Dean Moor Solar Farm

Applicant Response to Natural England Written Representation (REP2-060)

30 September 2025
Prepared by: Broadfield
PINS Ref: EN010155
Document Ref: D3.4
Deadline: 3
Revision: 1

**DEAN MOOR SOLAR FARM
APPLICANT RESPONSE TO REP2-060 (NE) WRITTEN
REPRESENTATION SUBMITTED AT DEADLINE 2
PLANNING INSPECTORATE REFERENCE EN010155
PREPARED ON BEHALF OF FVS DEAN MOOR LIMITED**

Project Title	
Client	
FVS Dean Moor Limited	
Title	
DEAN MOOR SOLAR FARM DEVELOPMENT CONSENT ORDER Exclusion Areas	
Scale: 1:12,500 @ A3	Date: 10/03/2025
Drawn: TL	Checked: JL
Figure: 3.5	Rev: A

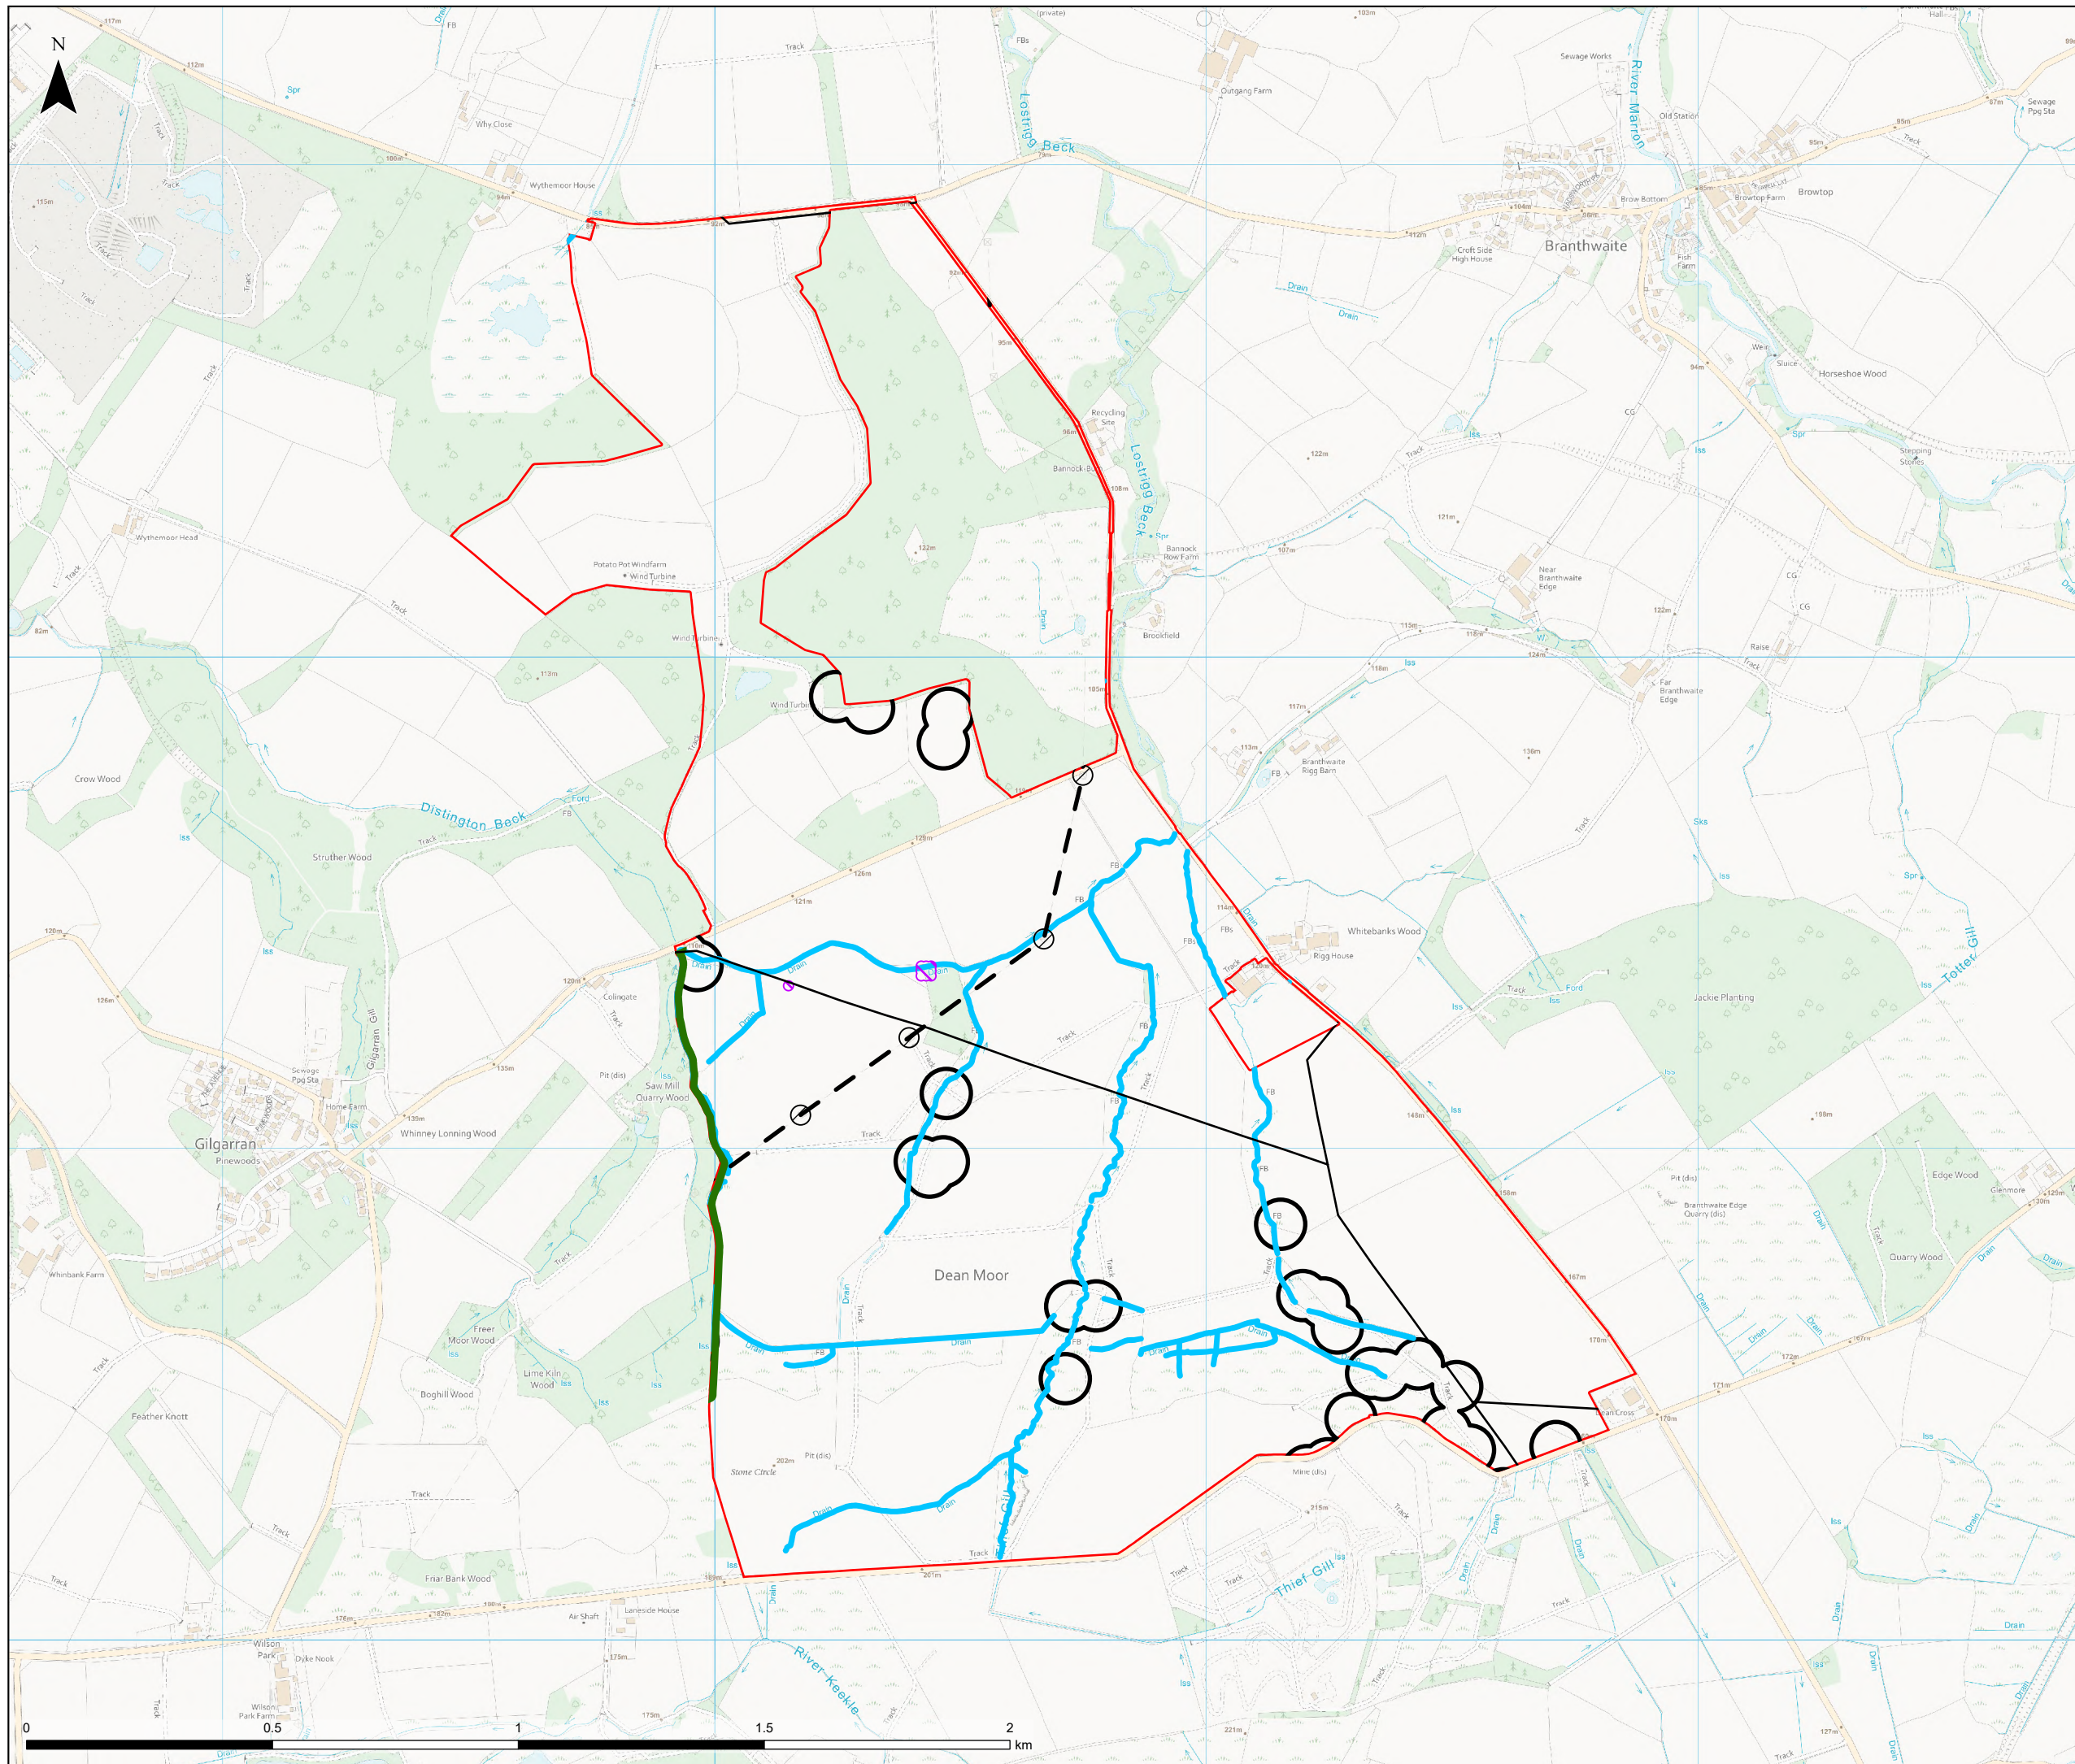
Ref	Matter Raised	Applicant Response
		<p><i>out in the CEMP, with provision for further protection zones to be established as a result of updated surveys in advance of and during construction.'</i></p>
NE.12	<p><i>The proposed Work Plans (Drawing ref EN010155/2.3) indicate that Work 3 works may be needed on the areas the applicant has outlined as deep peat. Work 3 works includes the laying of electric cables and access tracks both of which could cause degradation of the wider body of peat beyond the parameters of the infrastructure itself.</i></p>	<p>This matter has been raised previously and has been addressed within the 'Applicant Response to Relevant Representations' (ARRR) [REP1-002], which indicates, '<i>although peat is within Work Areas 3 and 6, the inclusions of peat within these areas is purely to enable any habitat enhancements or protection measures (such as fencing) in the vicinity of these areas of peat.</i>'</p> <p>There are two small areas of peat within Work No. 3, where it is theoretically possible to place cables and access tracks within these areas based on the Work No. as defined by the Design Parameters Document (DPD) [APP-028] and dDCO [REP2-004]</p> <p>However, this could only be undertaken through agreement of appropriate mitigation and a dedicated Method Statement (i.e. peat management plan) with Natural England. These commitments are described in section 11.3 of the OCEMP [APP-108].</p> <p>The Applicant considers that if development can be undertaken with mitigation deemed appropriate by the relevant authorities it does not need to be restricted by the Work No, and any development which could not be appropriately mitigated would not be allowed regardless of the theoretical potential of the Work No.</p> <p><i>11.3.18 Where activity needs to take place within identified areas of peat for these specific landscape and ecological enhancements, the following measures could be followed to ensure that any compaction or drying out of the peat resource is avoided:</i></p> <ul style="list-style-type: none"> <i>• Traffic is excluded from the areas of peat by way of physical temporary fencing. For any temporary traffic that is absolutely unavoidable methods shall follow those set out in the SMP and/or the CEMP.</i> <i>• Where areas of peat or soft ground are to be temporarily accessed during the works then suitable temporary access measures are used comprising either low ground pressure tracked plant or temporary trackway. Wheeled plant is not used in these areas to avoid risk of rutting.</i> <i>• The PC ensures any workers in this area have proven experience of working in a peat environment for all works in those areas.</i>

NE.13	<p><i>If larger areas of deep peat are present than currently indicated, then impacts on this from other proposed Work areas may also need to be considered.</i></p>	<p>Figure 1.4 within the PSR [APP-173] indicates peat is present at two locations within the Site where 'development' could take place. This aligns with the BGS records, which are provided in Figure 4 of the Phase 1 Ground Conditions Assessment [APP-169].</p> <p>It is noted that the areas of peat identified on the BGS records are confined to areas of the Site which are topographically unsuitable for solar, and other development, because they are generally within stream gullies. It is noted that the Applicant has committed to an 8m exclusion from the bank for watercourses (and these have been designed for in the Work Plans) (which covers much of the area shown on the BGS records). On this basis, it does not present a challenge for the Applicant to avoid these areas of peat with the detailed design.</p> <p>The need for further targeted ground investigation prior to commencement, and which would include further surveys for peat is acknowledged in Section 11.4 of the OCEMP [APP-108].</p> <p><i>'As discussed above, the detailed design of the Proposed Development will be informed by ground investigation and interpretative assessment.'</i></p> <p><i>'The CEMP will provide construction phase controls based on the detailed design, including measures (as / if found to be necessary) which may arise following the ground investigation.'</i></p>
